EL PASO COUNTY LAND DEVELOPMENT CODE

Date: 6/13/22

Foursquare at Sterlin

Type of Submittal:

DESIGNED BY	EAS	SCALE	DATE	03/08/2022
DRAWN BY	EAS	(H) 1" = 30'	SHEET	2 OF 19
CHECKED BY	(V) 1" = N/A	JOB NO.	1183.20

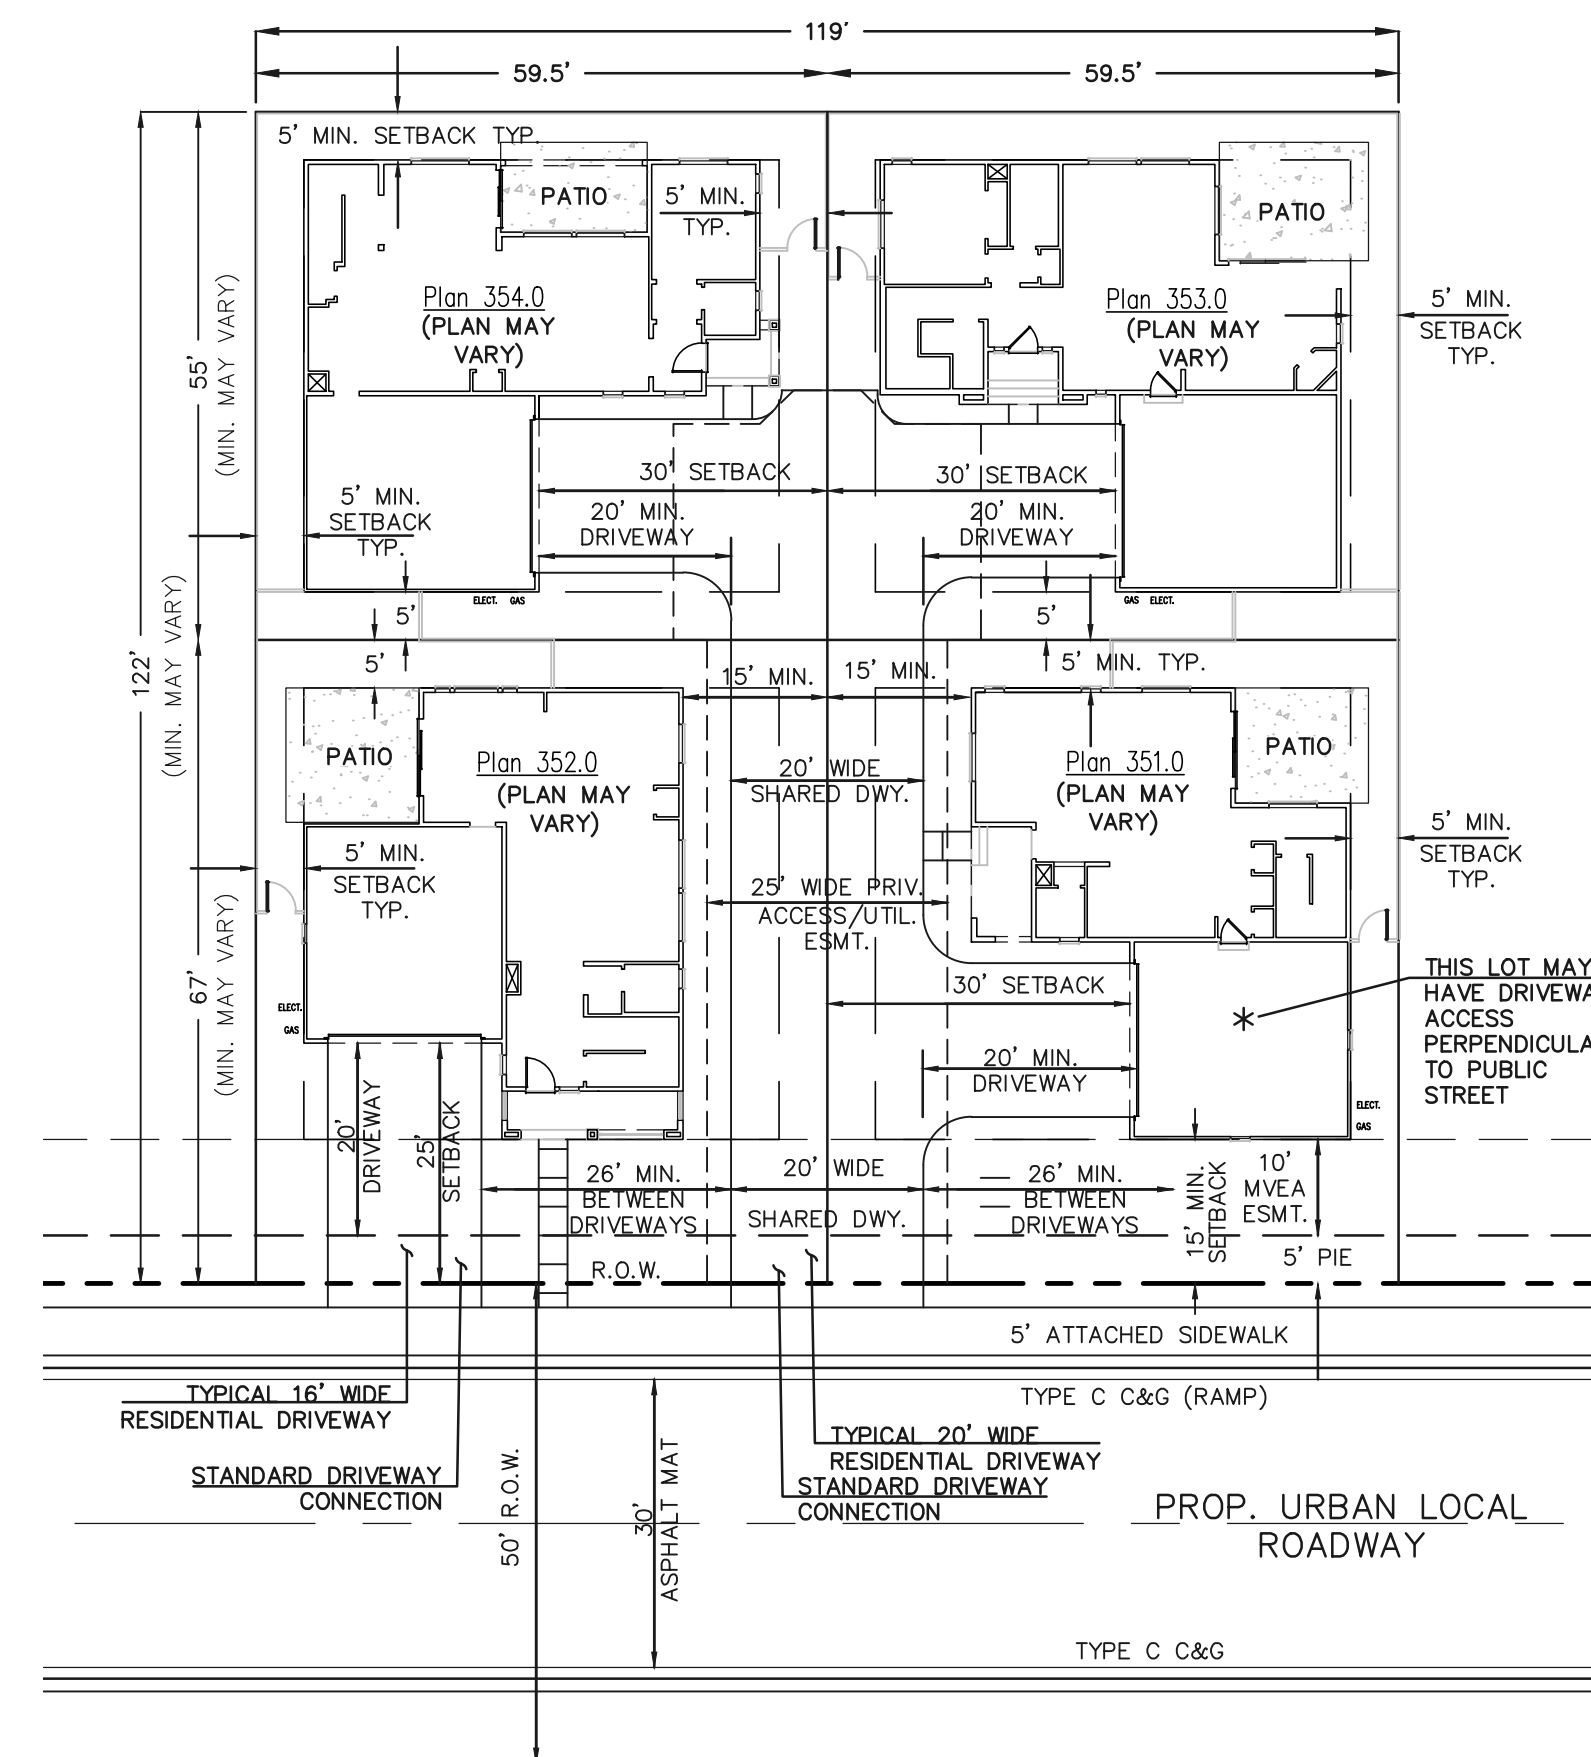
This should match the PUD and the sub summary sheet in the PUD. Perhaps the PUD needs to be modified to match this.
